**Natural England review of G5.9 Revised Ornithology Baseline - Revision: 01
[REP5-087]**

The construction and operation of Hornsea Project Four Offshore Wind Farm, located approximately 69 km from the East Riding of Yorkshire in the Southern North Sea, covering an area of approximately 468 km².

Planning Inspectorate Reference EN010098

4th July 2022

Figure 23: Predicted results for best-fitting guillemot model. Response refers to the number of birds identified per transect segment in the observation data.

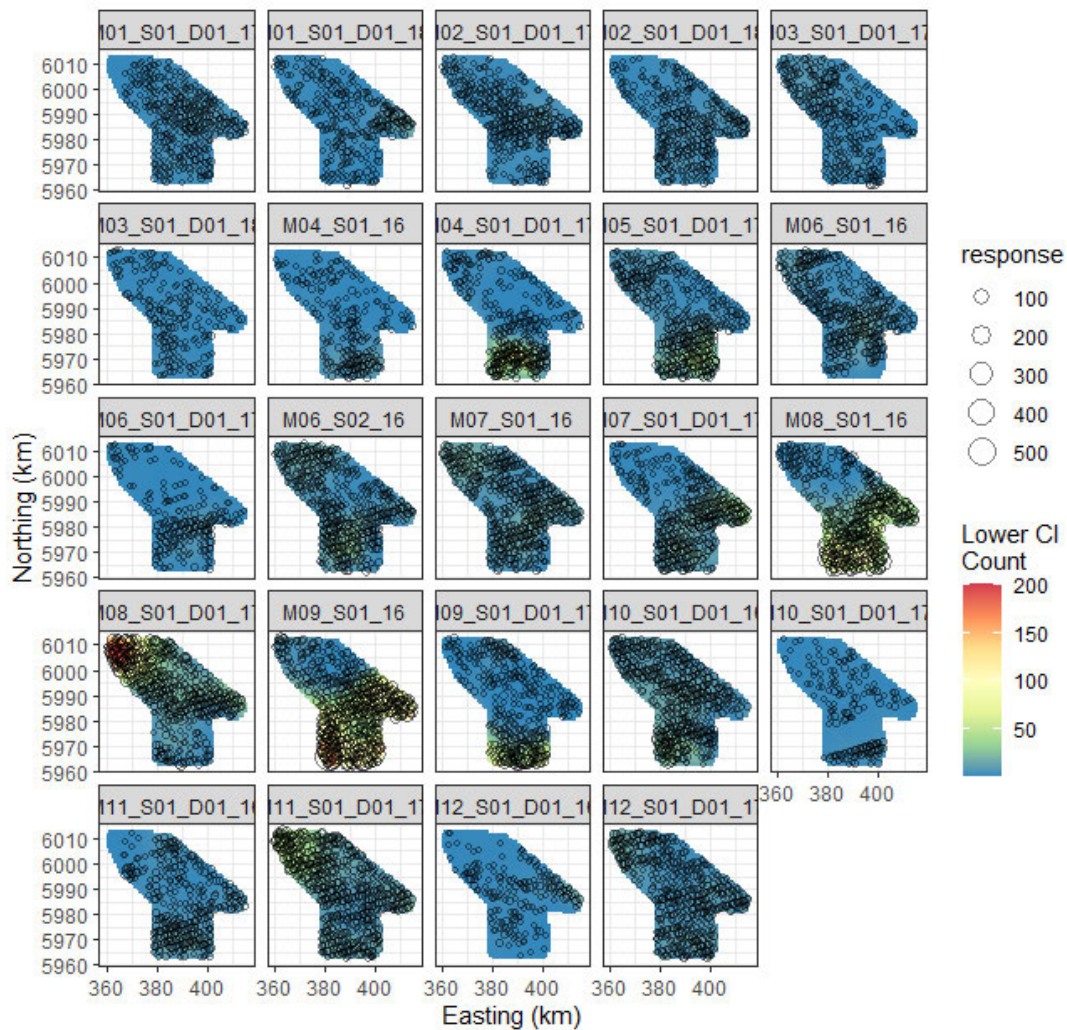
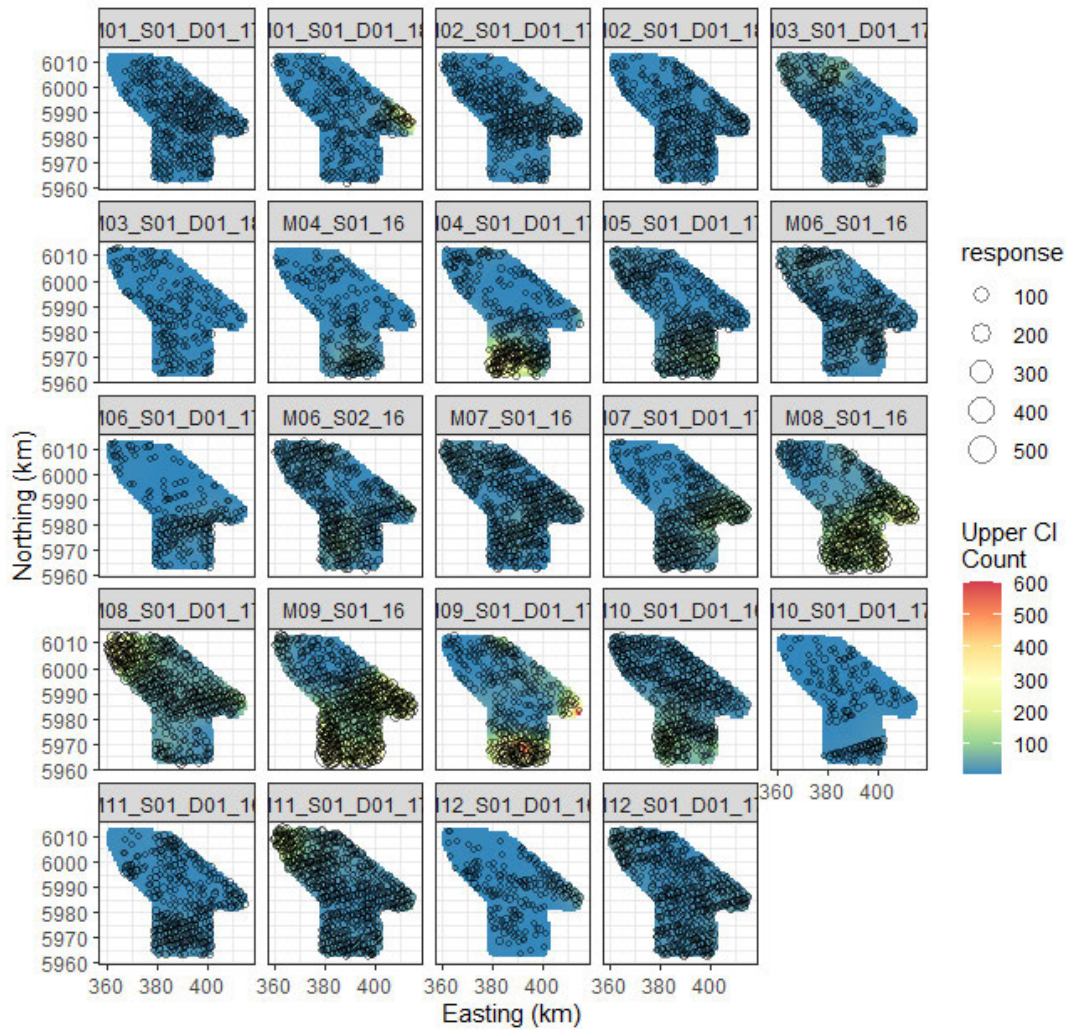
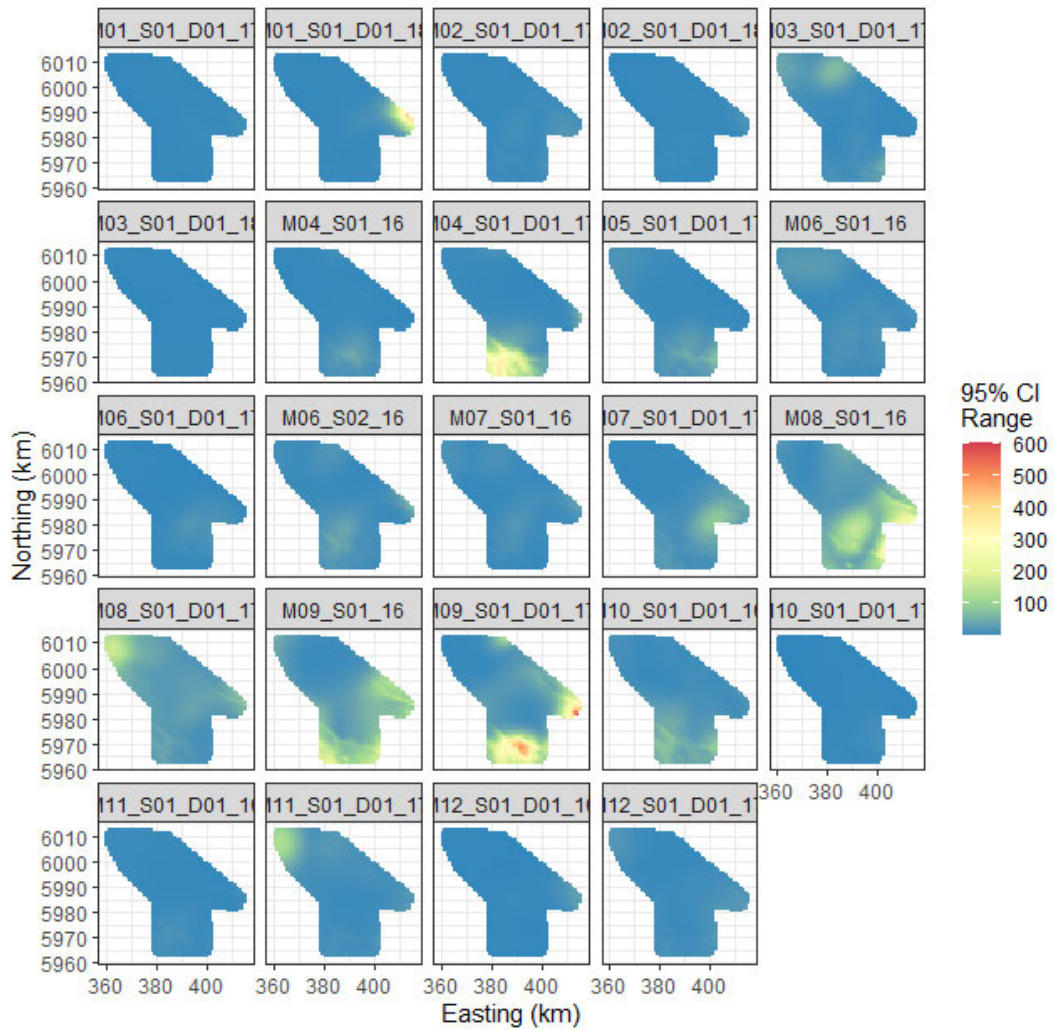
2. Clarification is needed as to how the model outputs are ordered for guillemot in Figures 23-25 of the revised baseline document. It looks like there might be a month/year labelling system but it isn't clear.

3. There is one survey in Figures 23-25 where there appears to be no guillemot on several transects at all (M10_S01_D01_17). Please confirm that this is correct, and not a plotting error or some other data treatment error.
